From: Laura Gibbons <Laura.Gibbons@arun.gov.uk>
Sent: 18 January 2022 09:34
To: Planning.Responses <Planning.Responses@arun.gov.uk>
Cc: Simon Davis <Simon.Davis@arun.gov.uk>
Subject: RE: Planning Re-Consultation on: A/255/21/DOC

Engineers Further Comments Regarding Condition 5

Application No: **A/255/21/DOC**

Registered: 1st December 2021
Site Address: Merry England Nurseries Dappers Lane Angmering BN16 4EU
Grid Reference: 507336 105060
Category: Discharge of Condi
Description of Works: Approval of details reserved by condition imposed under A/142/16/OUT relating to conditions 5-as built drawings of the implemented SuDS scheme together with a completion report, 8-updated copy of the management manual or confirm in writing no changes are required to the manual & 23-verification report demonstrating completion of the works set out in the approved remediation strategy.

<p>cgs civils Consulting Civil Engineers</p>					
CLIENT		GD GROUP			
ARCHITECT		CITYZEN			
JOB TITLE		MERRY ENGLAND ANGMERING			
DRAWING TITLE		DRAINAGE LAYOUT			
DRAWN	LH	ENGINEER	CS	CHECKED	CS
DATE	SEPT 2019		1:200		
DRAWING No.	C1249	STATUS	C	DRAWING No.	100
REV	A

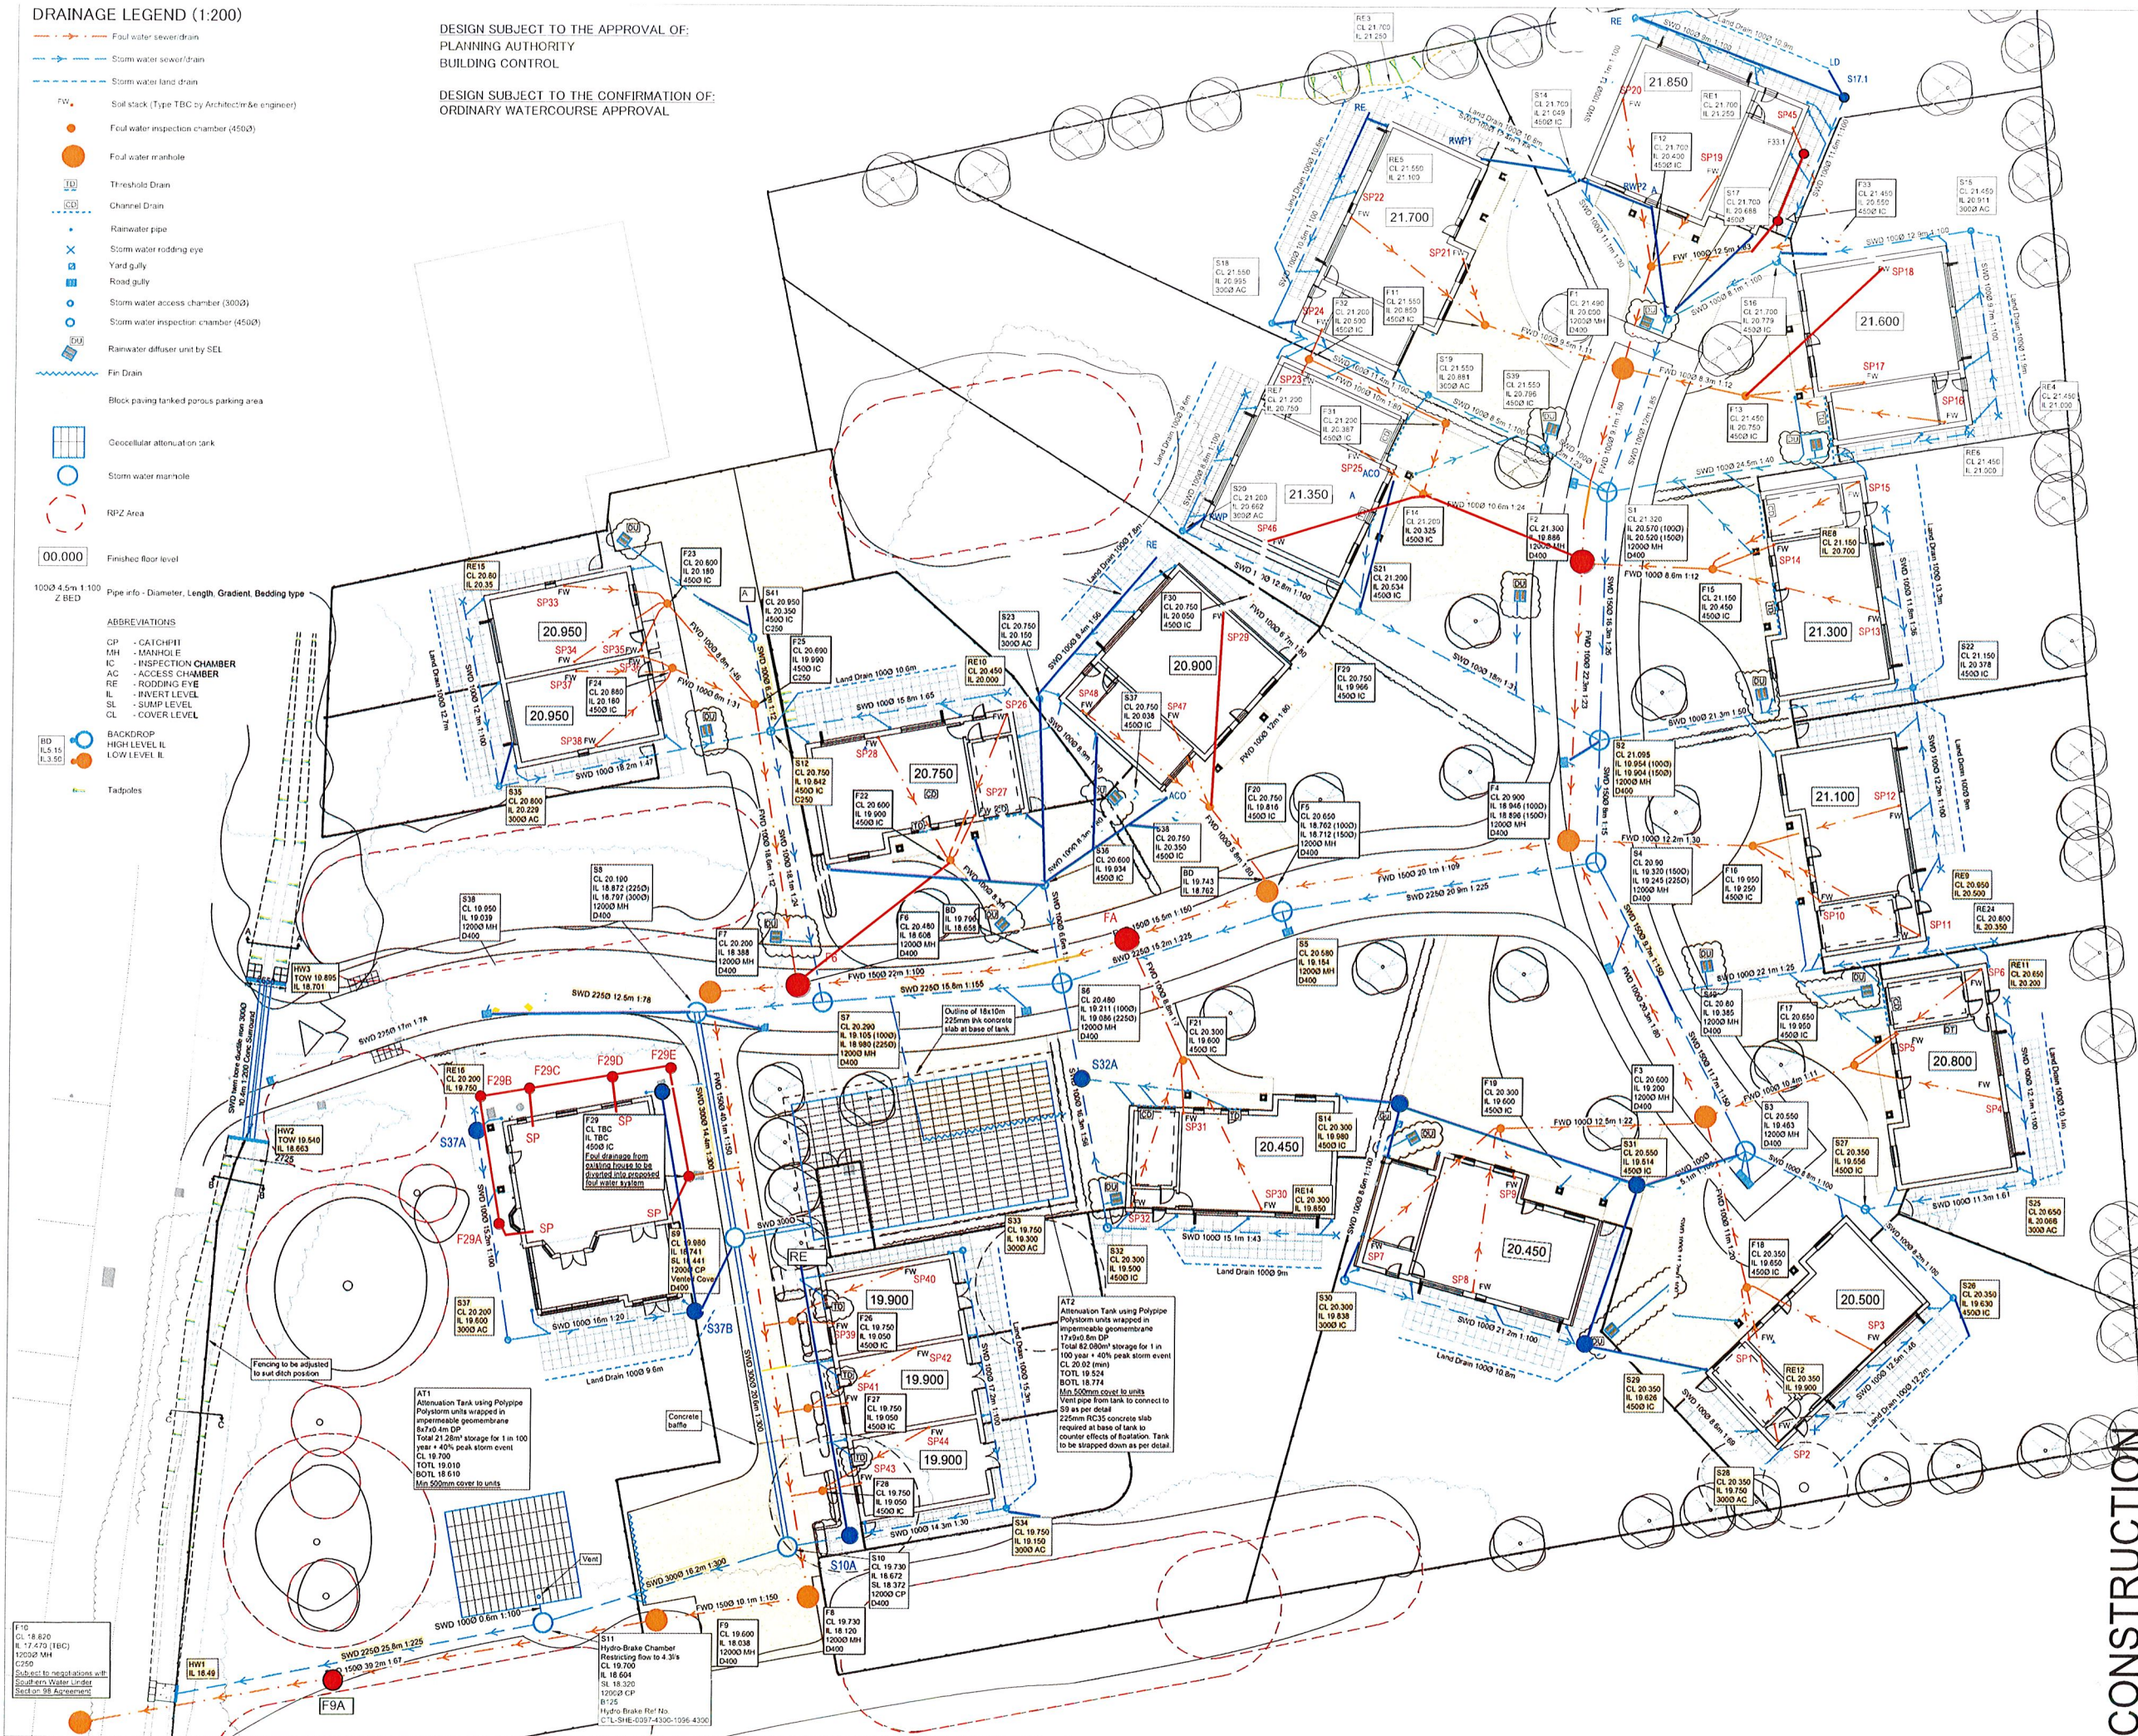
The invoice for the attenuation tanks states that 196 Polystorm PSM1 crates were ordered. We believe that the design requires over 700 crates. — We are locating the additional invoice for the remaining 320No. attenuation crates, I will send this over to you for review, (for the record there are 516 No. crates required to achieve the attenuation capacities to AT1 & AT2.) Awaited. Our calculations based upon crates of dimensions 1m x 0.5m x 0.4m indicate that 724 crates are required to provide AT1 to 8m x 7m x 0.4m and AT2 to 17m x 9m x 0.8m as per design.

The photos supplied to evidence the construction of AT2 clearly show that this attenuation tank has been constructed to only one crate depth, despite the design specifying two crates depth. The photo also

appears to show Terram surround the crates, but no impermeable tanking membrane.- there are two layers of 1m x 0.5m x 0.4m Polystorm PSM1 crates, with 500mm cover, you can see from the adjacent ground levels on Fig 9 that this is the first 1m x 0.5m x 0.4mm layer of crates, Fig 8 shows the second layer of crates, when I send the additional crate invoice over this should show the correct amount of crates. The photos provided do not show this clearly. Please also provide evidence that a tanking membrane has been installed.

Please also clearly detail if each of the defects picked up by the independent engineer have been rectified. Five photos have been supplied, but more than 5 defects were identified. -- Please refer to the attached Drainage Report Update dated 13th January 2022, this shows the defects picked up in the Independent Engineers Report being remediated. No evidence has been submitted to show if S7 has been uncovered and the defects corrected.

We do not recommend discharge of condition 5 at this time as the evidence supplied raises significant questions about the construction. Please supply evidence that construction has occurred in accordance with the design. It may be that some areas need to be reconstructed.
